Application for a non-material amendment following a grant of planning permission.

Number	99
Suffix	
Property name	
Address line 1	Victoria Drive
Address line 2	
Address line 3	
Town/city	Bognor Regis
Postcode	PO21 2DZ
Description of site location must be completed if postcode is not known:	
Easting (x)	493156
Northing (y)	99686

Demolition of existing dwelling & erection of a three story building to provide 9 No. flats, 6 No. 1 bed & 3 No. 2 bed units with associated amenity areas, access & car parking.	
Reference number:	BR/281/18/PL
Date of decision	24/03/2020

Change from external wooden cladding to parts of the walls and replacement with painted render to the front and side and cement based horizontal cladding to the rear dormer. The lowering of the rear portion of the crowned roof.

PROPOSED NORTH EAST ELEVATION

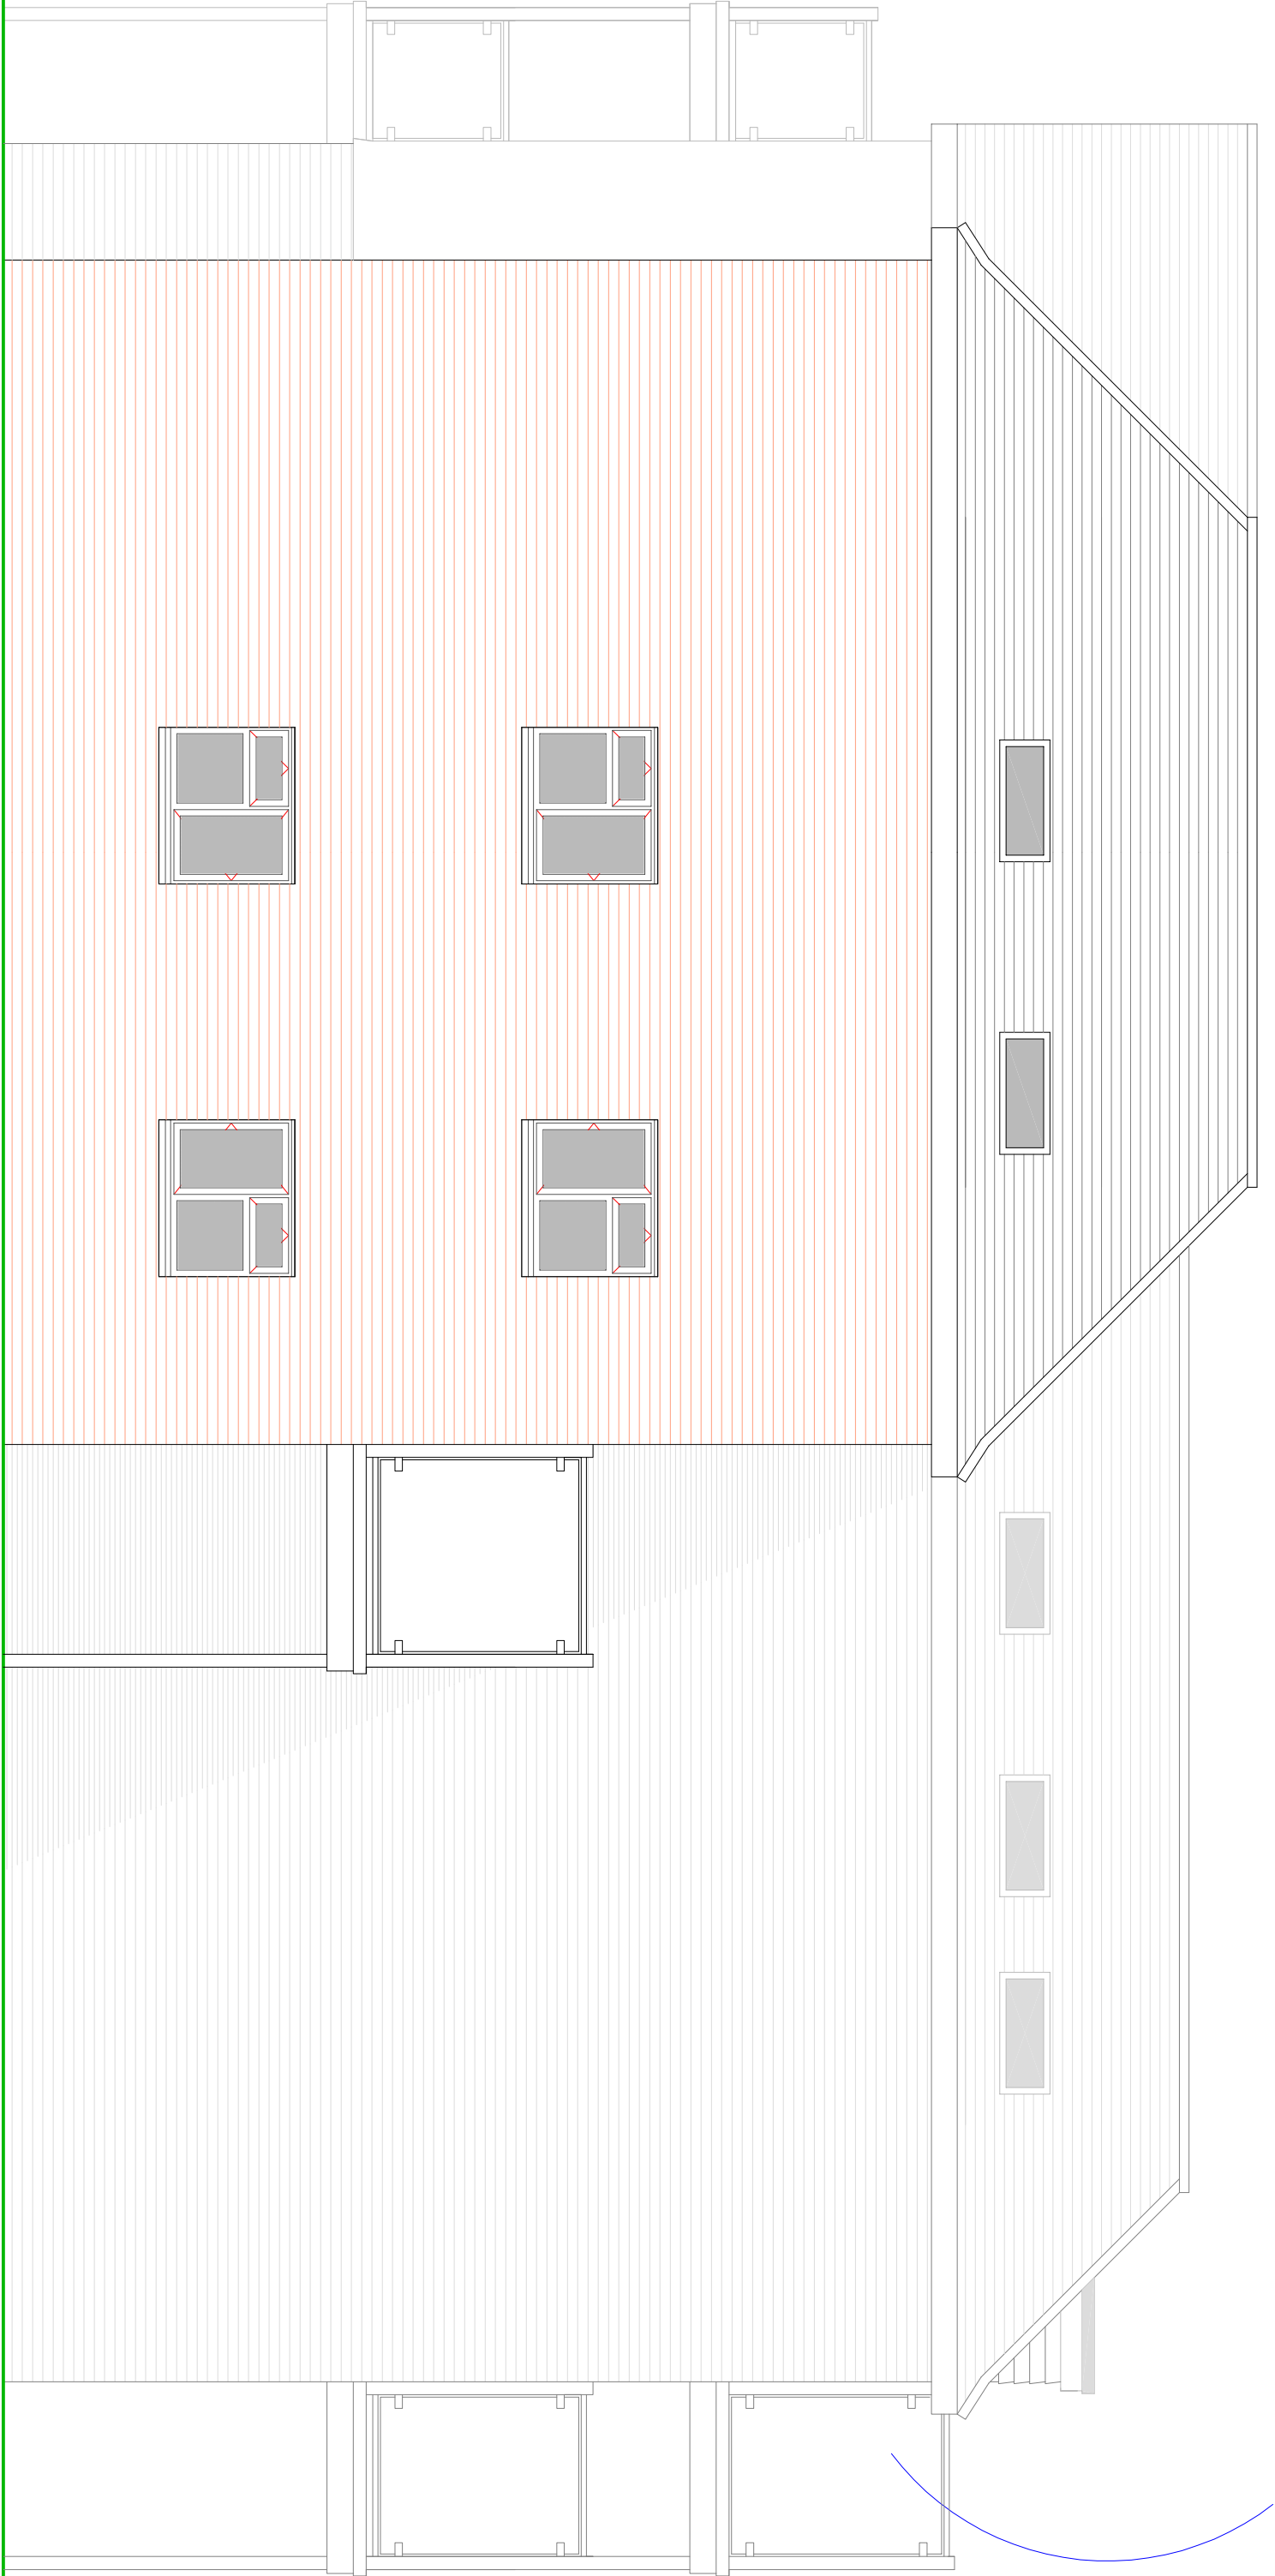
Change in cladding - for fire safety reasons.

Change in roof height - for structural stability reasons.
